To: All Staff
From: Environmental Health
Date: August 6, 2025
Subject: SPF-25-00004 Final Plat Review Comments

TO: All Staff
FROM: Public Works Plan Review Team
DATE: August 5, 2025
SUBJECT: SPF-25-00004 Fahlgren

CDS received an application for final short plat for SPF-25-00004 Fahlgren (SP-24-00010 Fahlgren). Please review the submitted documents at the links below and verify compliance with the conditions and your department's submitted comments. Please find the preliminary approval document attached.

SHEET 1 OF 2

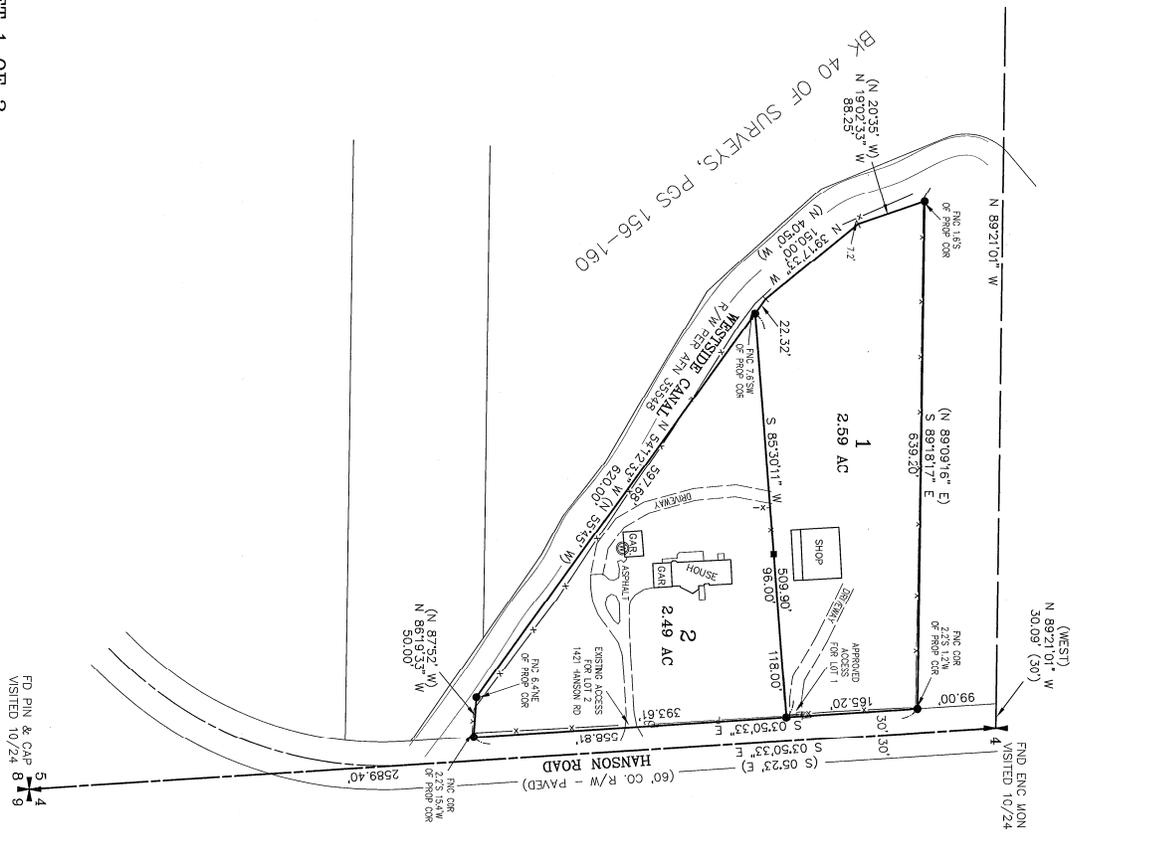
| SURVEY | <p>Please include offset distances between the fence and the property deed line.</p> <p>OF NOTE Due to the simple nature of this Short Plat, Lot closures are not needed, nor were they reviewed. (JT)</p> |
